WEST SUSSEX COUNTY COUNCIL CONSULTATION

TO:	Arun District Council FAO: Zac Denton
FROM:	Highways, WSCC
DATE:	16 th July 2018
LOCATION:	4, Hawthorn Road, Littlehampton, West Sussex, BN17 7LT
SUBJECT:	LU/176/18/PD Notification for Prior Approval under Class O for change of use from an office (Class B1) to a dwelling (Class C3).
RECOMMENDATION:	ADVICE
S106 CONTRIBUTION TOTAL:	£N/A

Dwg 1818-03B

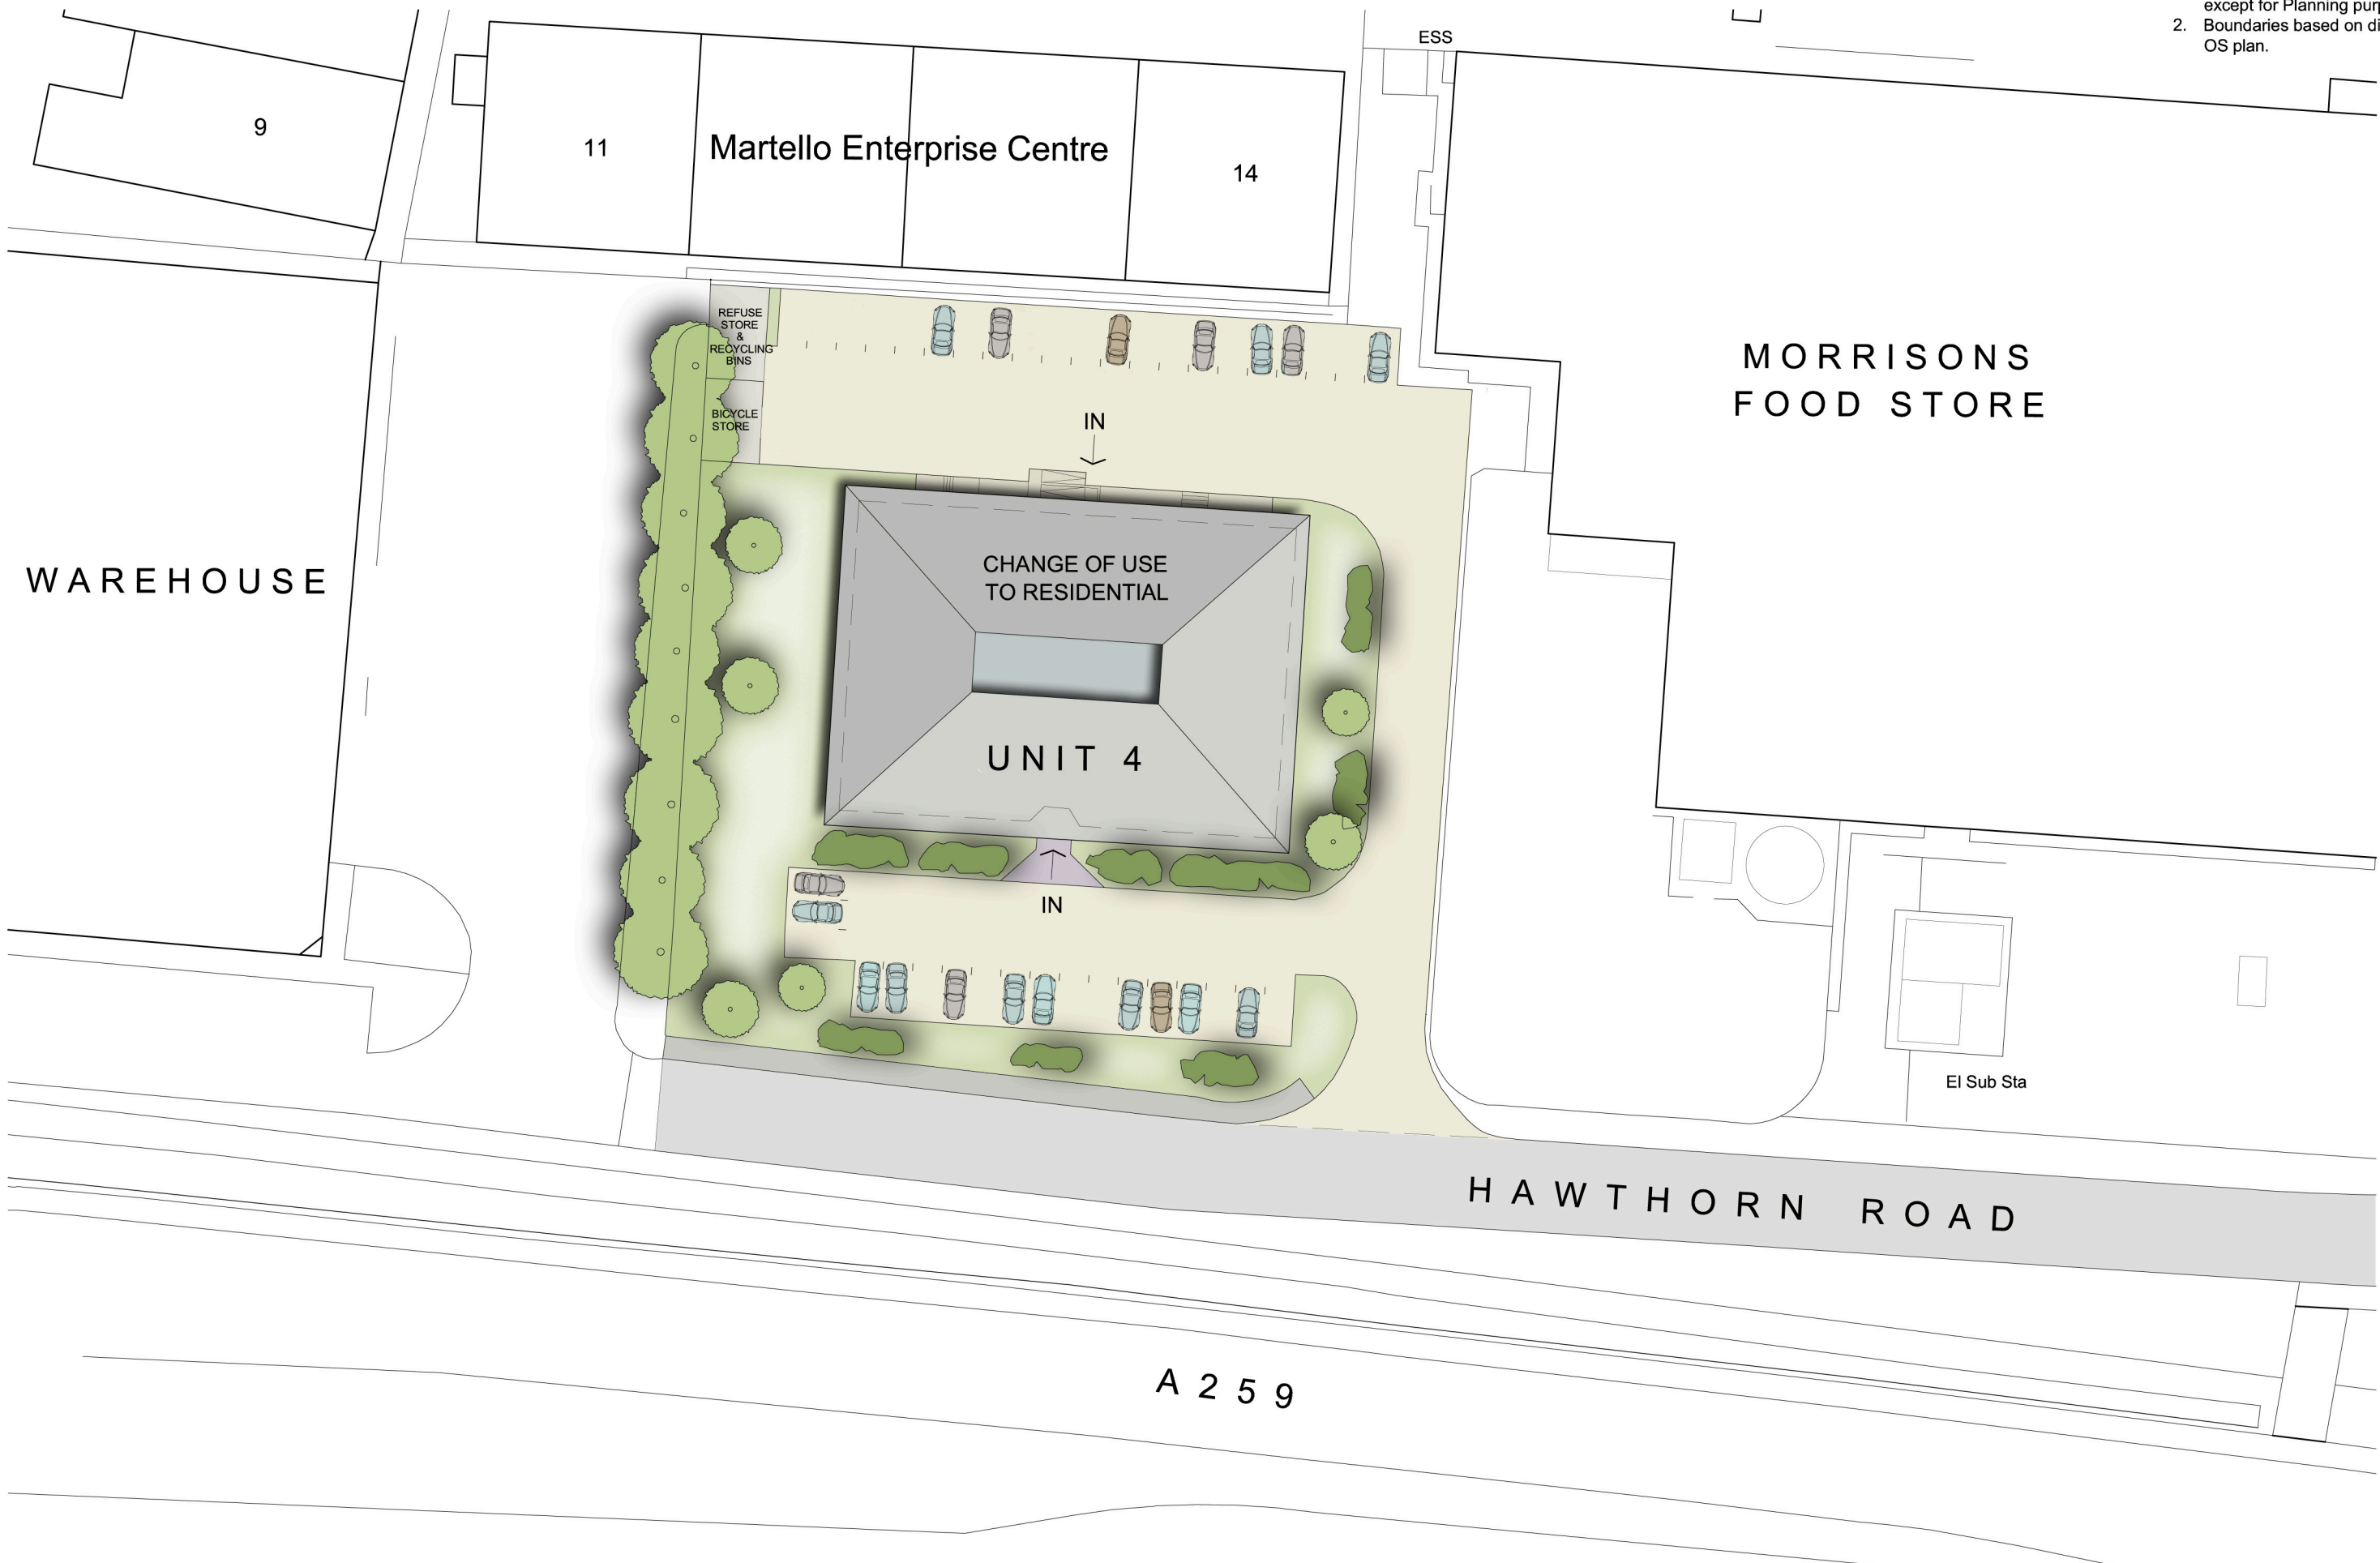
The existing parking area for the offices is included within the red edging. The prior notification process does not enable parking provision or other matters relating to accessibility to be considered. Nevertheless, 39 of the dedicated car parking spaces are to be retained for the residential use (with with over 3 spaces available per apartment).
